From: [Holly Erdman](#)
To: [Jeremiah Cromie](#); [Samantha Cox](#)
Cc: [Jeremy Johnston](#)
Subject: RE: Map of Proposed Wells for Tiger, Wildcat and Timothy Plats
Date: Thursday, July 29, 2021 5:12:02 PM

SUBJECT: Timothy Short Plat SP-08-00018

RE: WDFW comments on SP-08-00018 Timothy Short Plat

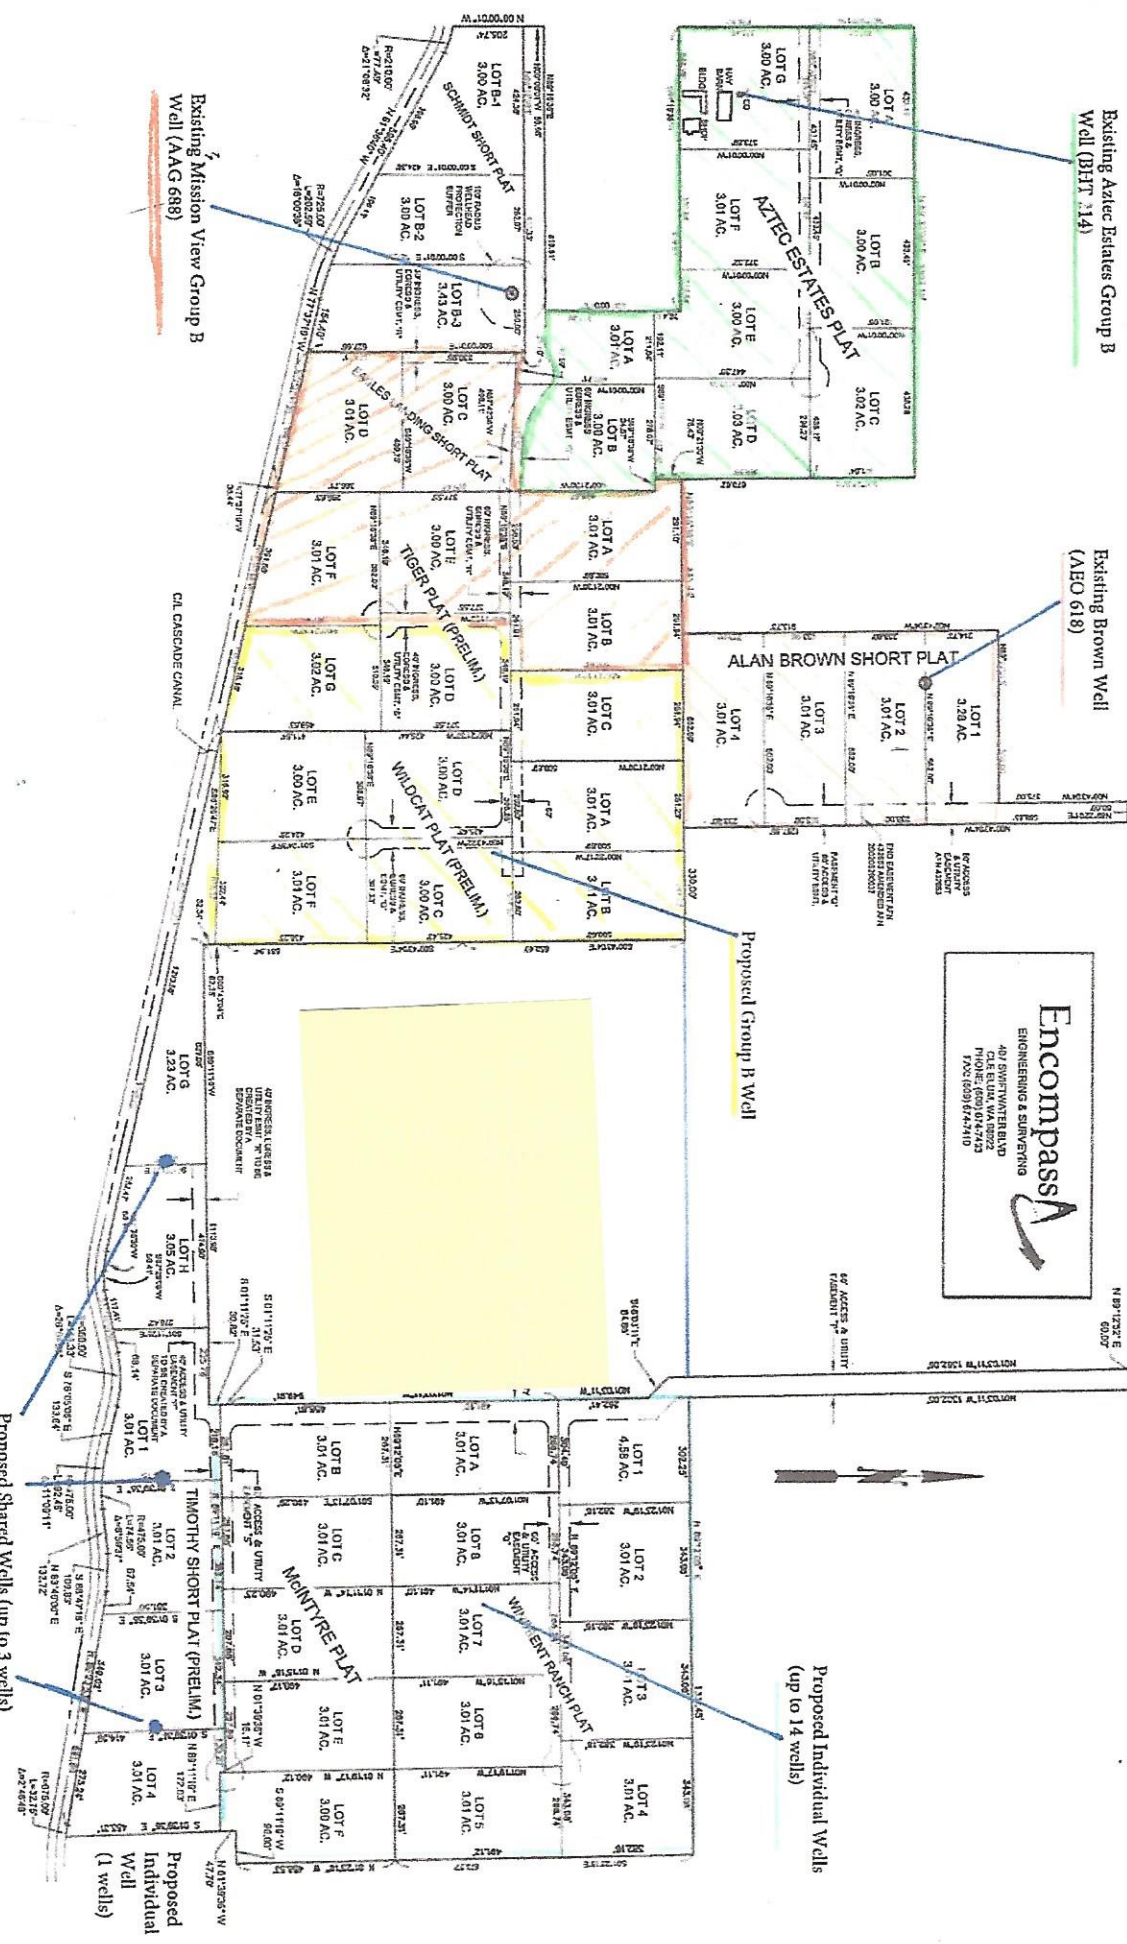
A well site inspection needs to be done to approve the well AEO618 as a Group B well. A well site inspection also needs to be done to approve the well for the Wildcat Plat well. The proposed shared wells on the Timothy SP wells need to be moved so they are at least 50 feet from all property lines. All proposed individual and shared wells must have approved individual well site review applications submitted and approved.

TIMOTHY SHORT PLAT
A PTN. OF SEC. 32, T. 18N, R. 19E, W.M.
KITITAS COUNTY, WASHINGTON

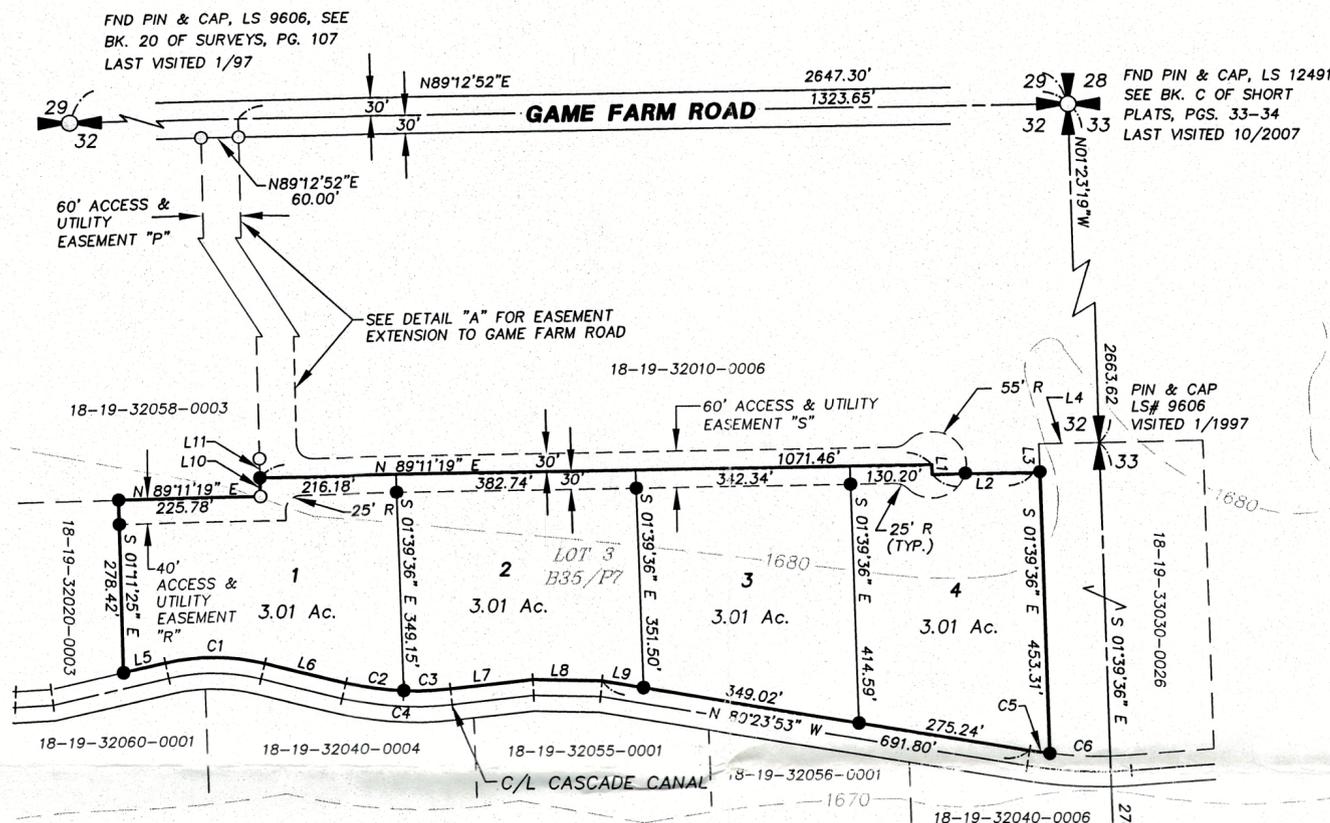
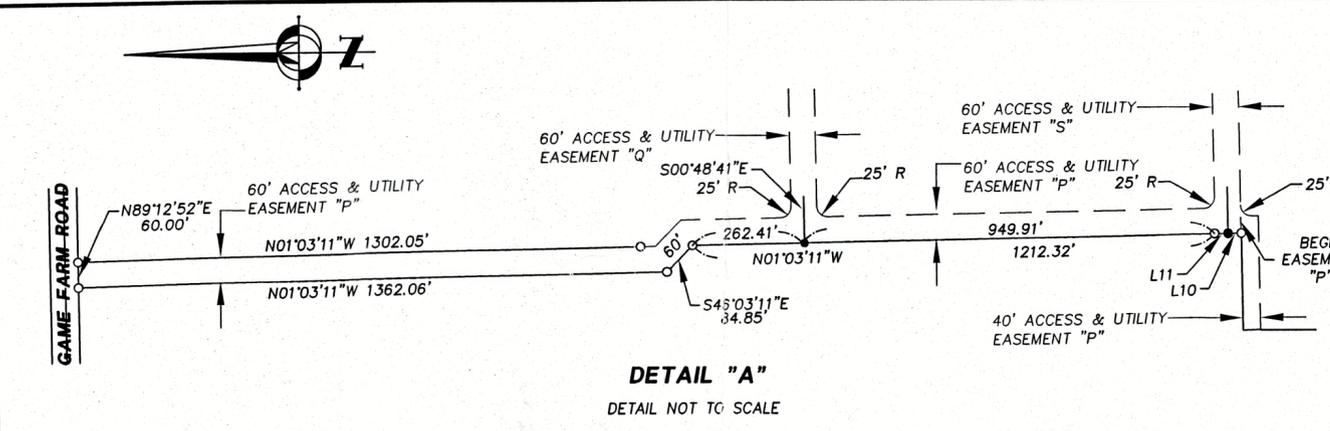
This Short Plat has been held up for 13 years due to development problems. Comments below reflect the need to update the Plat to current information.

1. For the 60' access easement, please reference AFN200710220075, 201010050029 and 201010050030.
2. The Plat will need to be stamped and signed by a surveyor actively licensed in the State of Washington.
3. Adjacent property owners list will need to be updated.
4. An updated title report will need to be reviewed prior to final approval for the Timothy Short Plat.
